## Department of Transportation

SH 85/87  
El Paso County

RE: Venetucci Farms Business Event Center  
Special Use EA 212/AL2115

Figure 1
SITE LOCATION

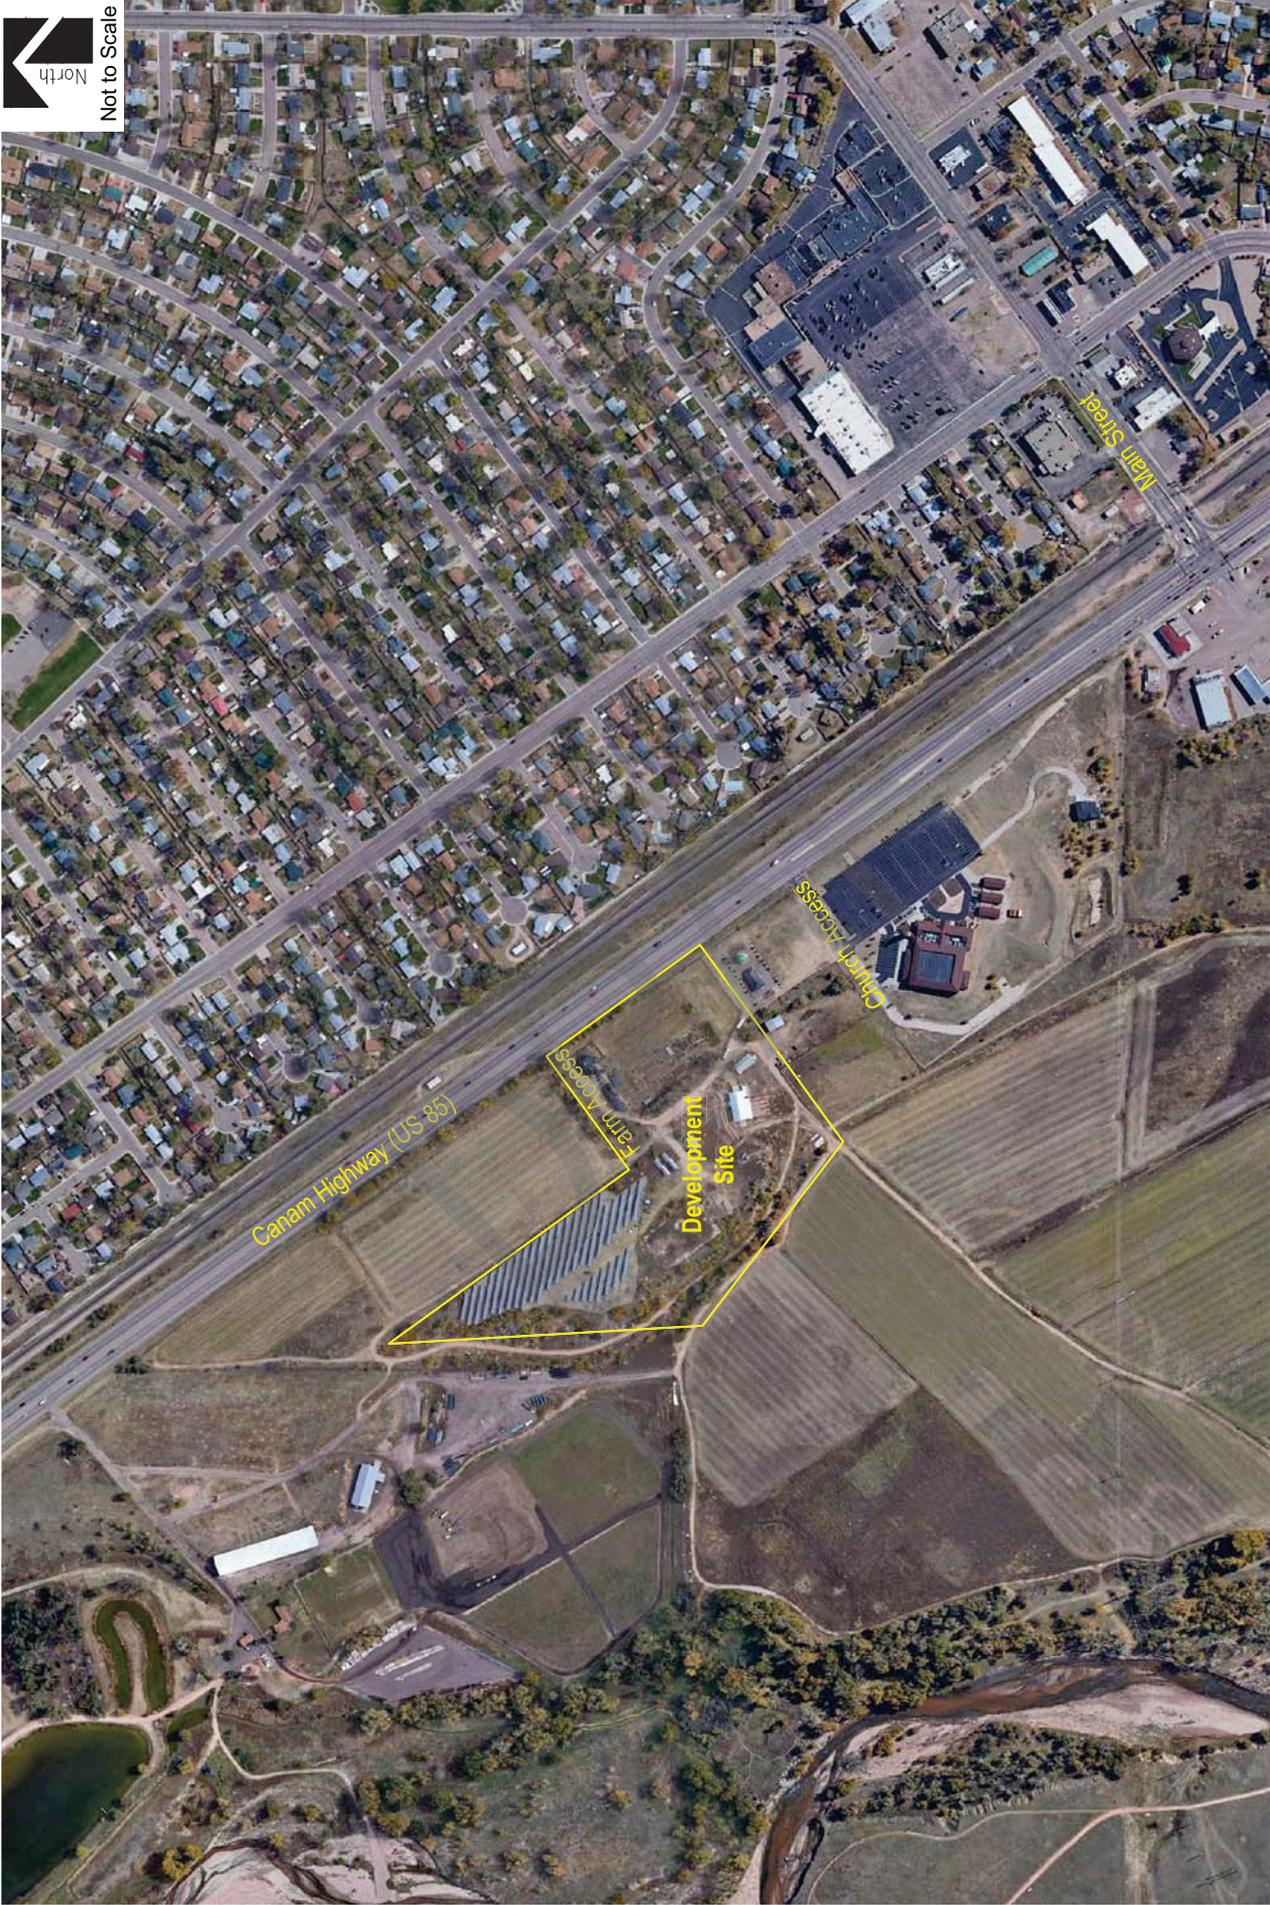
- The Traffic Memo does not address the existing use of Church access by the church and any impact it may or may not have on the analysis.
- The Letter of Intent states that the Church Access is used by Venetucci Farms via informal agreement. A formal agreement is needed and shall be provided to CDOT for the State to issue access for two adjacent properties.

- The Farm Access and the Church Access do not meet the one-half mile spacing standard for NR-A Highway for full-movement accesses.
- A right turn acceleration lane is required at the Farm Access due to the high traffic volume on the highway and posted speed greater than 40 MPH - as was required previously for the

Church Access. This will likely overlap with the right turn deceleration lane for the Church Access making a continuous auxiliary lane.

- The Two Way Left Turn Lane (TWLTL) serves no purpose along this section of highway from the Church Access to east of the Farm Access. There are currently no accesses on the north/east side of the highway in this stretch and the only accesses on the south/west side are the accesses in question. It is likely used as an ad hoc left turn acceleration lane due to the traffic volumes and speeds on the highway. The TWLTL shall be eliminated from the Church Access to east of the Farm Access by striping a double yellow median with left turn acceleration lanes for both accesses as well as a left turn deceleration for the Farm Access. Plans depicting the appropriate dimensions and pavement markings per CDOT specifications must be provided for review. If spacing requirements cannot be met due to the dimensions, movements may be restricted at the Farm Access.
